Consultation Response from KC, Conservation & Design**2023/91676 90, New North Road, Edgerton, Huddersfield, HD1 5NE****Listed Building Consent for change of use of offices to bed and breakfast, installation of lightwells and new window opening to sides(within a Conservation area)****Date Responded: 28.03.2024****Responding Officer: Sue Brooks****Responding Ref: HUD 27/1043**

Following the previous Conservation and Design response dated 13 October 2023, further information and amendments have been submitted. These revised details are assessed below and include the previous responses. The associated planning application 2023/91675 is assessed separately.

PROPOSED EACH SHOWER
INTERNAL PODS AND W/C

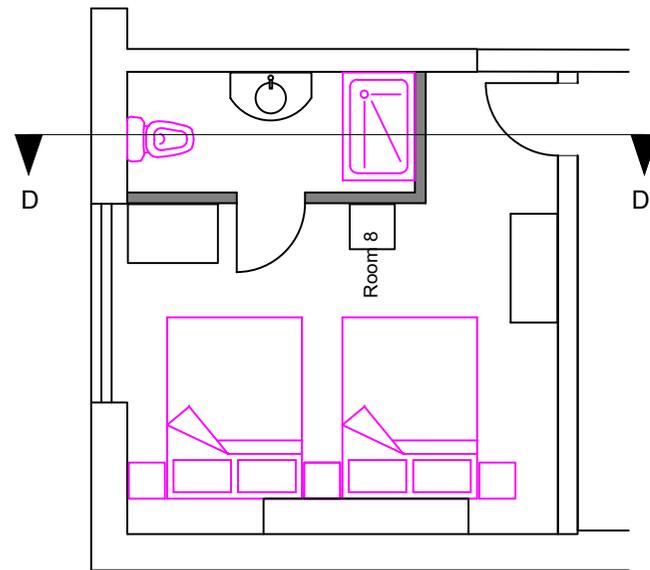
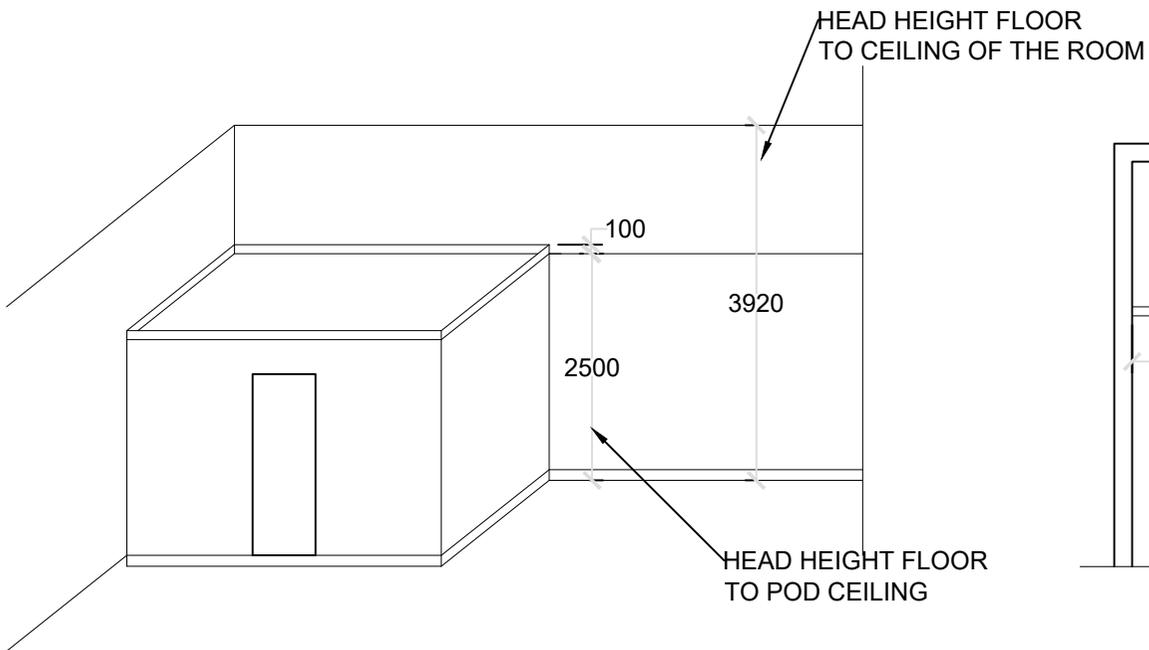
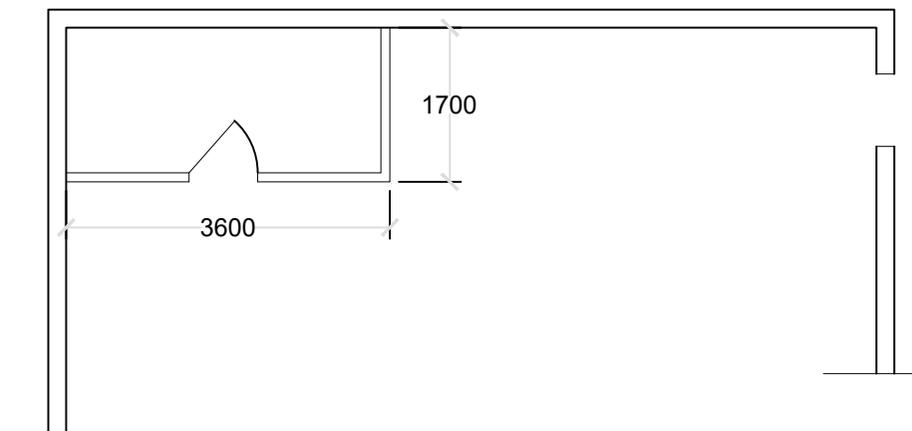
- Ensuites – indicative drawings of the bathroom pods in rooms 6, 8, 9, 10, 11, 12 and 13 have been submitted and show that skirtings and picture rails are retained and boxed in, and the proposed floor plans show that new soil vent pipes will be connected into existing drainage.

In rooms with surviving architectural details these interventions will lead to less than substantial harm to the significance of the listed building. However, the original plan forms can still be understood, and the harm has been mitigated against by the proposed pods being set below the decorative cornices within the rooms and fixed around the skirtings to ensure that these historic details are retained. The pods could be removed in the future if they are no longer required. We consider that the public benefits of providing a viable use for the building outweighs this slight harm. We recommend that a condition is applied requiring architectural details to be retained and protected from damage as part of the installation.

- No architectural details shall be removed without consent. This includes (but is not exclusive to) windows including historic glass, window shutters, historic internal doors, architraves, skirtings, picture rails, covings, chimney breasts, fireplaces including surrounds and historic ironwork. New boxings, pipework and drainage runs shall be installed carefully to avoid damage to architectural details. Reason: To ensure the satisfactory appearance of the development on completion to retain the significance of the designated heritage asset and to accord with Policy LP35 of the Kirklees Local Plan, as well as Chapter 16 of the National Planning Policy Framework.

TITLE
CHANGE OF USE FROM OFFICES TO BED AND BREAKFAST
PROPOSED & EXISTING SIDE ELEVATIONS

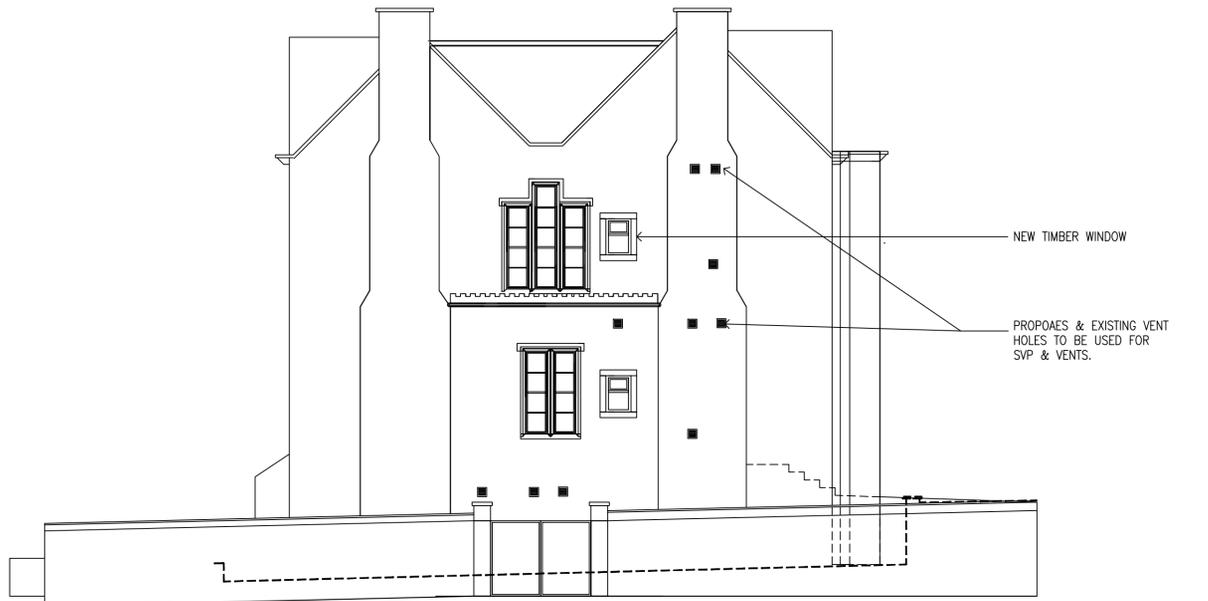
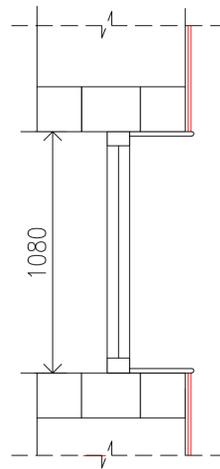
- First floor gable window – The introduction of a small first-floor window to room 11 to the right of the stair window is simple in design and timber framed, with the ashlar stone surround matching the ground floor window opening below. The minor harm to significance is outweighed by providing natural light and ventilation into the existing room.
Note: This window has been approved under application 2023/93777.

- Notwithstanding the information submitted, the first-floor gable window shall be timber framed and match the small ground floor window below in all respects including the depth within the reveal, with an ashlar stone surround and projecting stone cill. Friction hinges and visible trickle vents shall not be permitted. Reason: To ensure the satisfactory appearance of the development on completion to retain the significance of the designated heritage asset and to accord with Policy LP35 of the Kirklees Local Plan, as well as Chapter 16 of the National Planning Policy Framework.
